From: Iain Osenton <iain.osenton@cherwell-dc.gov.uk>
Sent: 31 May 2022 15:39
To: Planning <Planning@Cherwell-DC.gov.uk>; dcregistration <dcregistration@Cherwell-DC.gov.uk>
Cc: David Lowin <David.Lowin@Cherwell-DC.gov.uk>
Subject: 22/01144/F - CDC Arboriculture

Please see below from desk based assessment my initial observations.
Comment – More information required.

date	10 NOVEMBER 2021	drawn by	GY
drawing number	edp2425_d040a	checked	BW
scale	1:6,000 @ A3	QA	RB

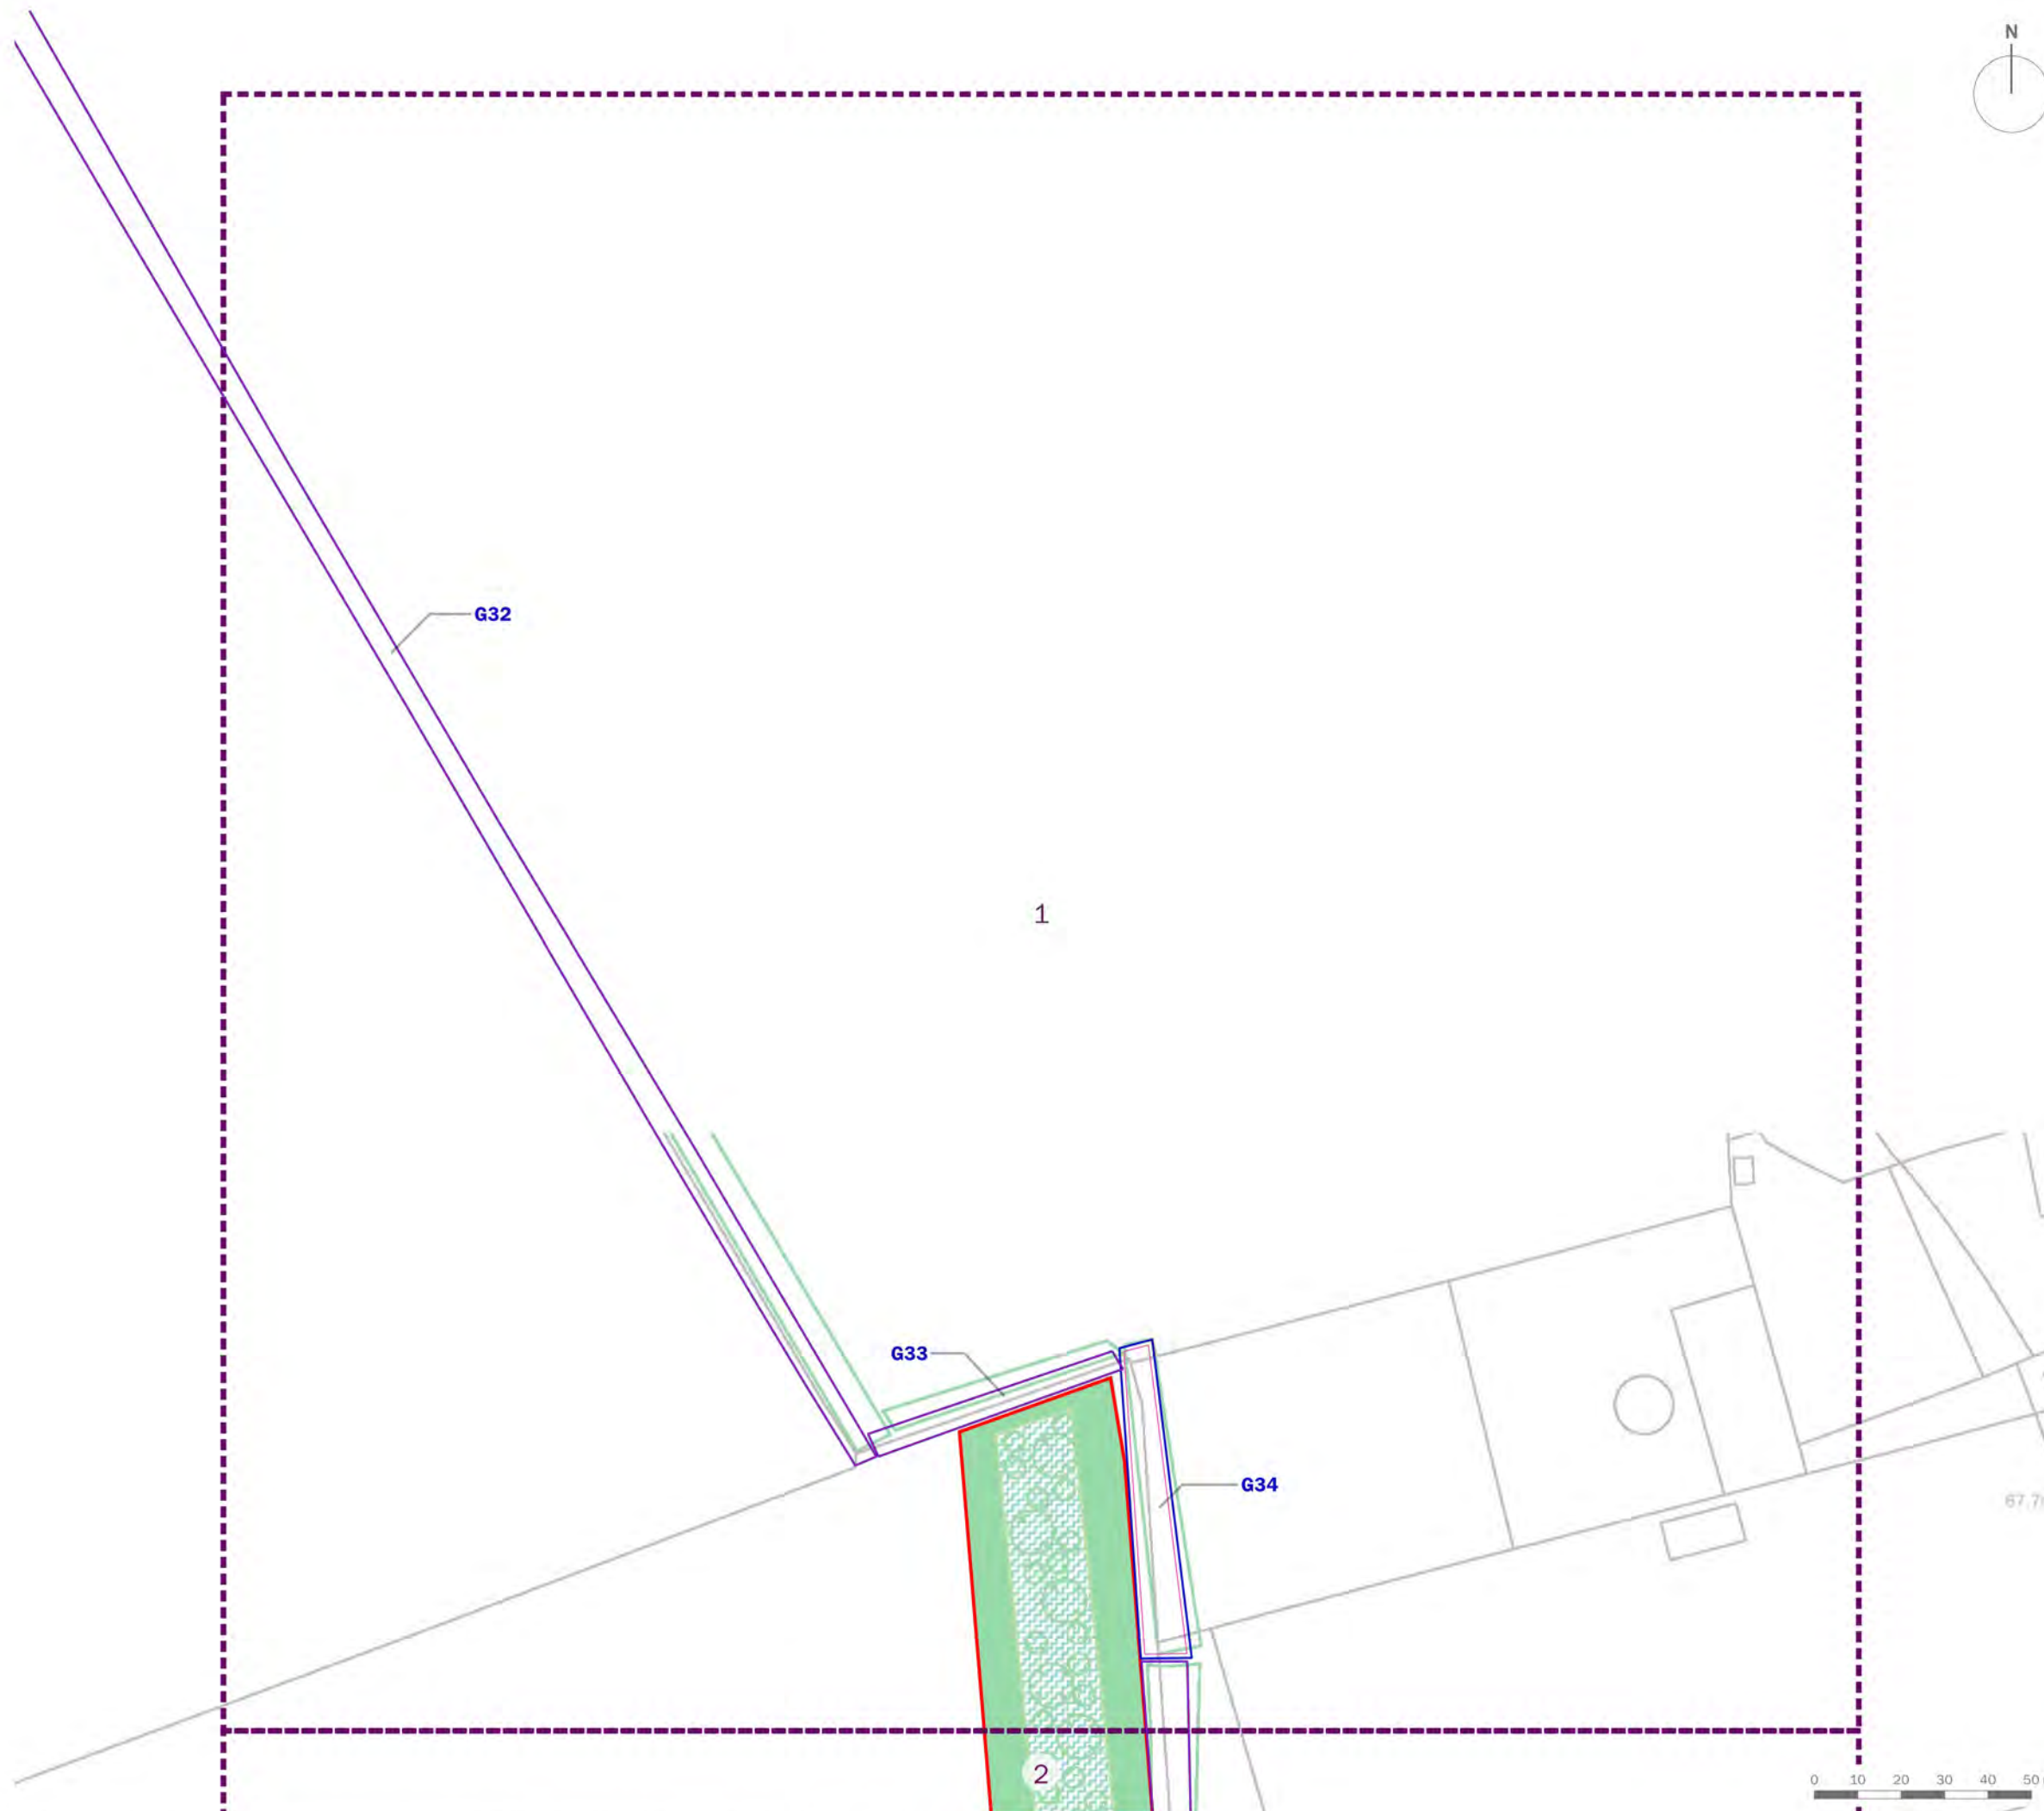
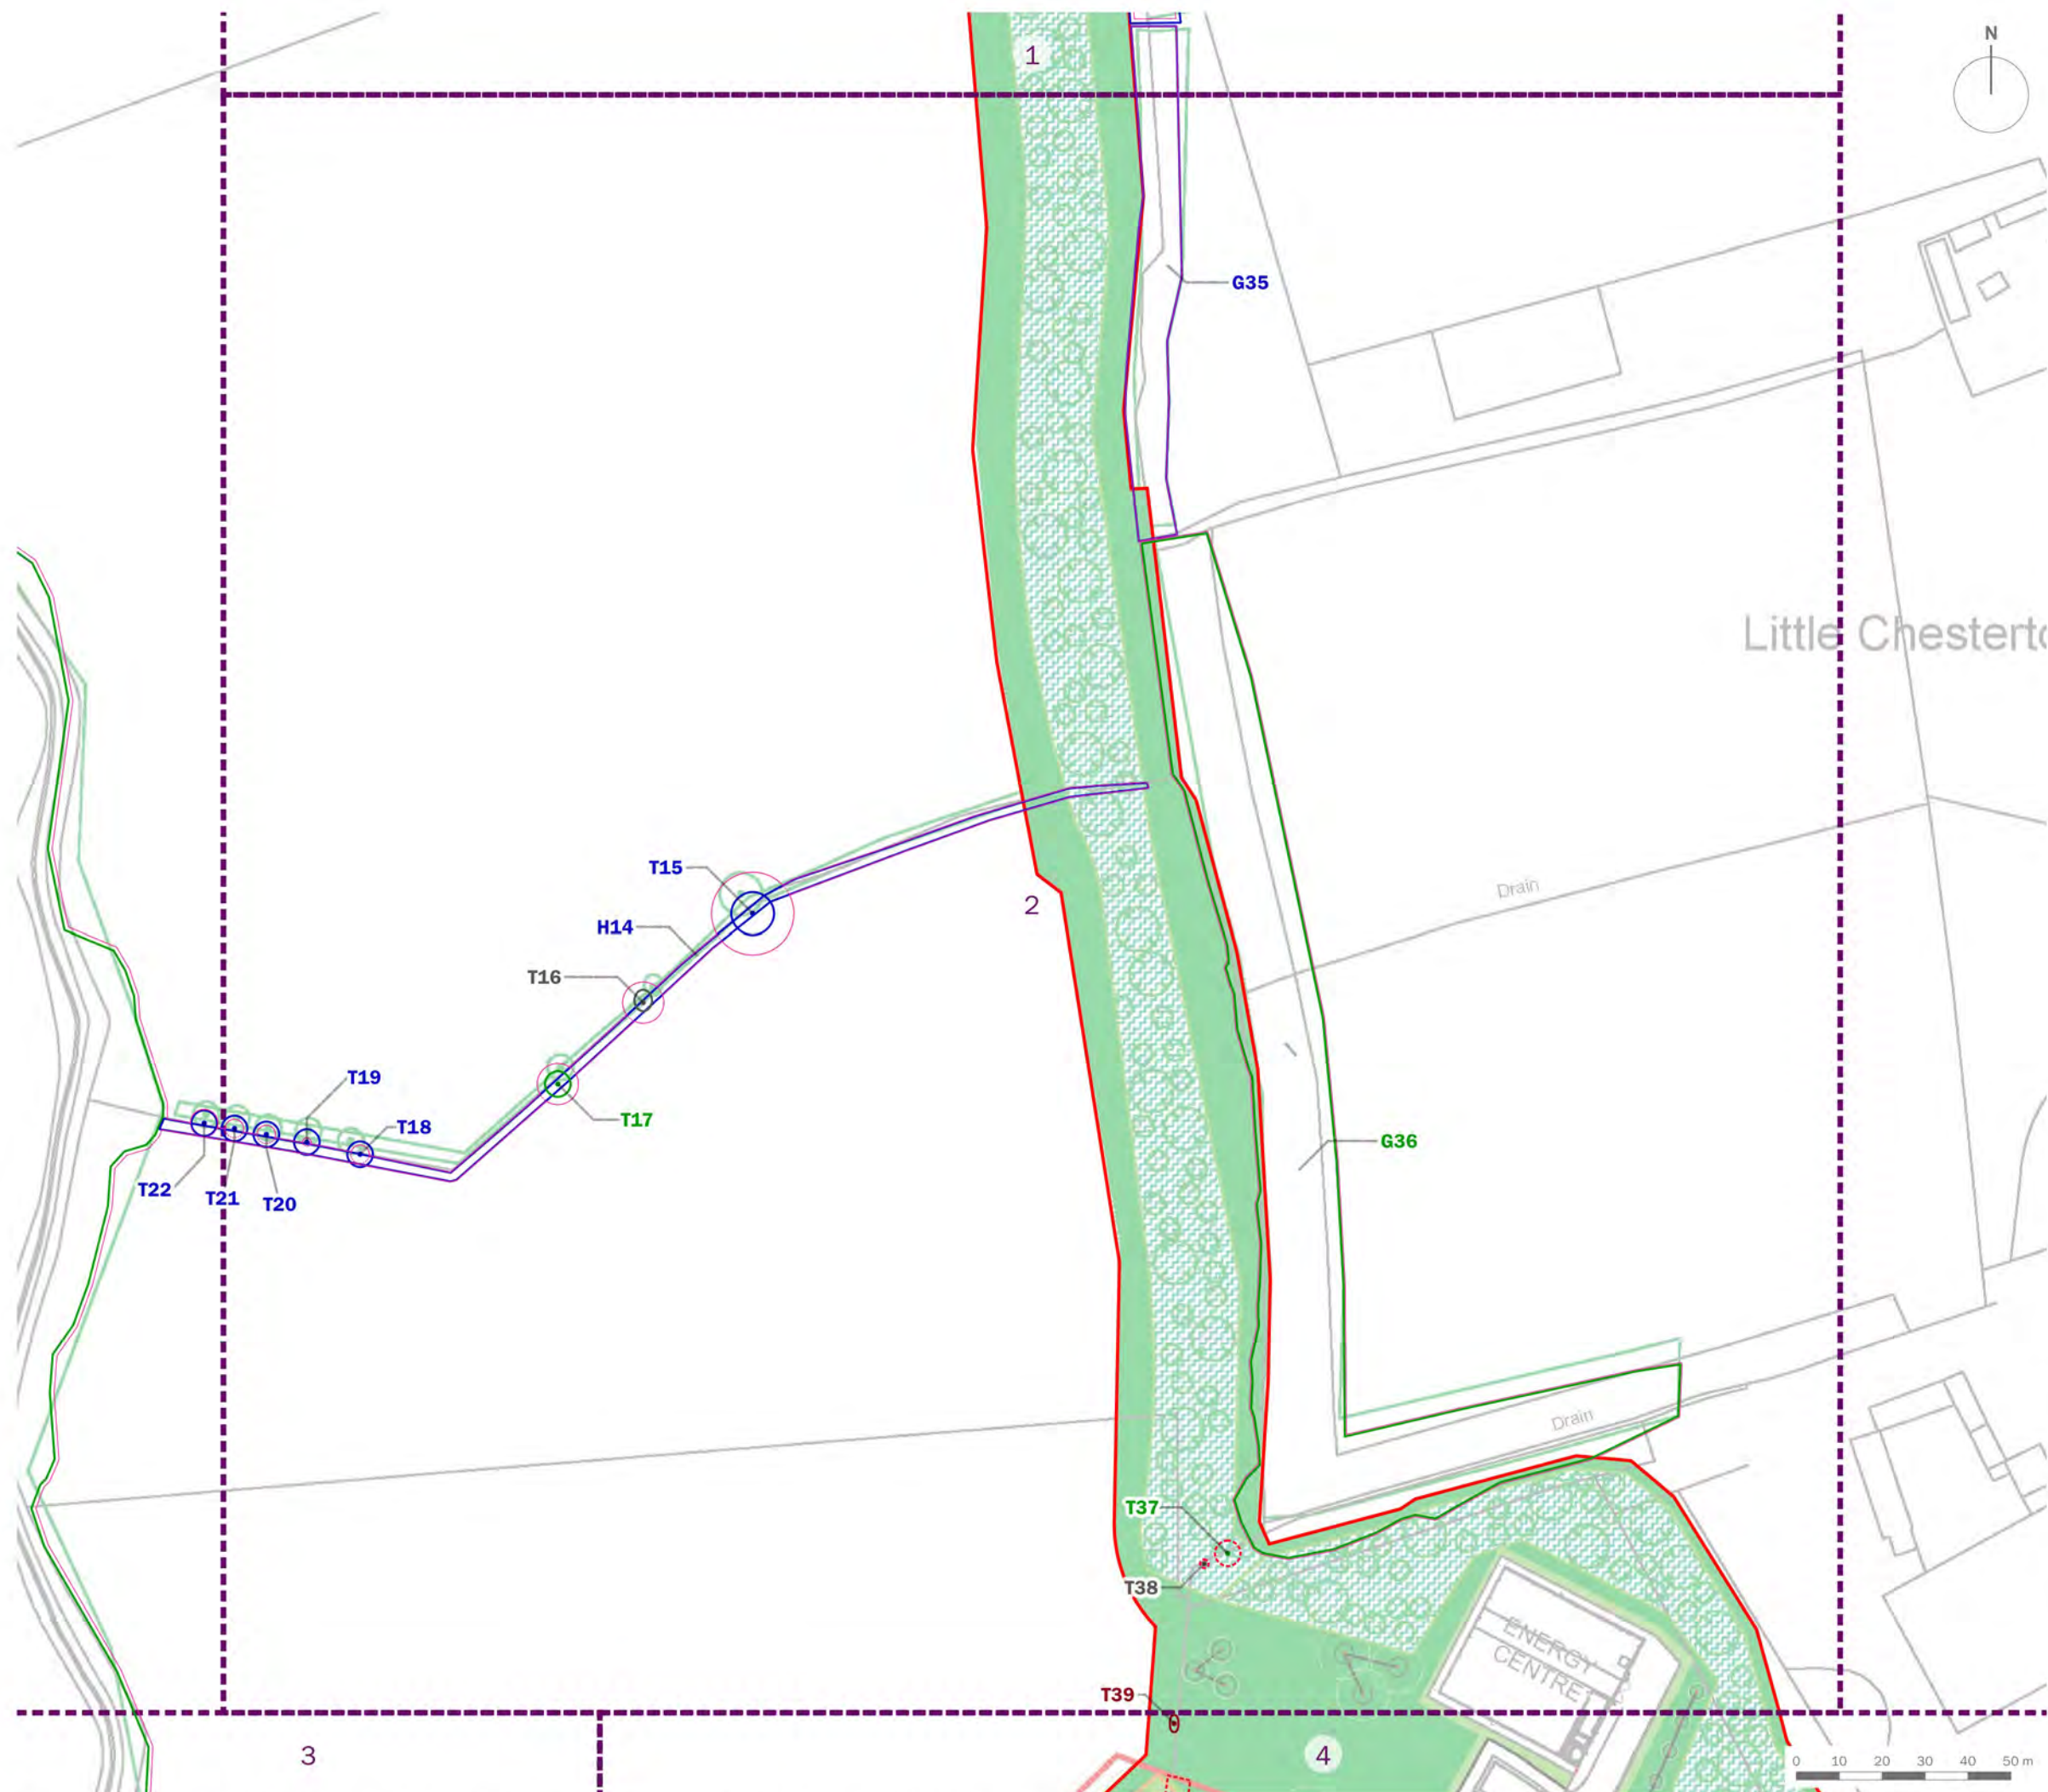
- Confirm justification for T37 removal.
- Confirm if hedgerows proposed for removal are protected under hedgerow regulations (if this is covered in ecological assessment please state).
- Method for operations upon ancient woodland border/buffer area. (See below comments for method statement).

An AMS is included within the report however, some further details will be required. It is acknowledged some of this information is likely unavailable currently. 3.14 states service locations, whilst remaining outside RPAs are subject to confirmation from the applicant. The AMS does not include a plan demonstrating tree protection fencing, though it is acknowledged the majority of vegetation sits outside the area of development. The AMS does not include a methodology for working within the ancient woodland buffer for redirecting drainage, and does not include details such as the site compounds location mentioned in 3.20.

- Methodology for working within the ancient woodland buffer.
- Confirmation of service locations.
- Confirmation of site compound location.
- Full AMS/TPP plan including access.
